CITY OF PORTLAND, MAINE

RE: 4-Lot Residential Subdivision, 696 Allen Avenue

PUBLIC WORKS ENGINEERING
MEMORANDUM

To: Rick Knowland, Senior Planner
From: Anthony Lombardo, P.E., Project Engineer
Date: July 19, 1999
Subject: McMullin Subdivision.... 696 Allen Ave.

TYPICAL TRENCH SECTION - DRIVEWAYS

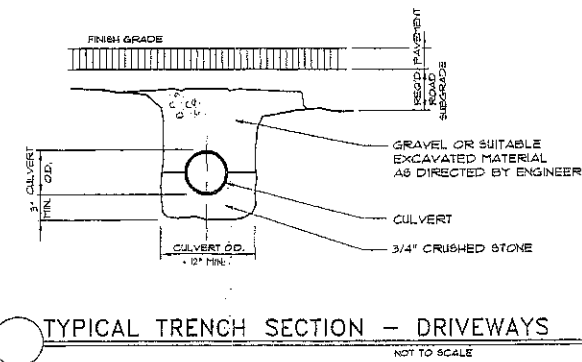
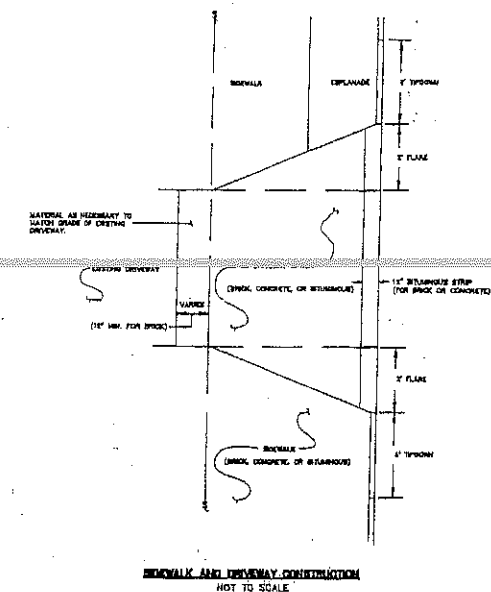
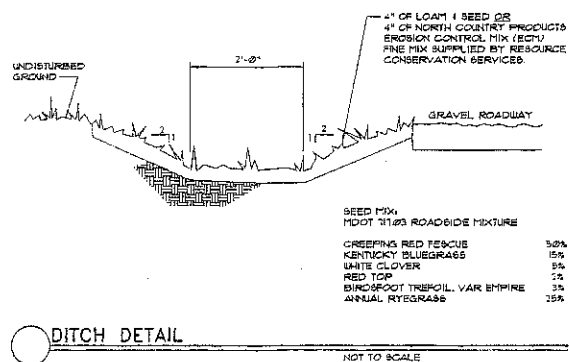
- *A detailed erosion and sediment control plan needs to be included as part of the plan set.*
- *Construction details for driveway entrances, culvert installation, etc. will need to be included in the plans.*

Construction details as requested by Tony Lombardo at Public Works have been included on the detail sheet.
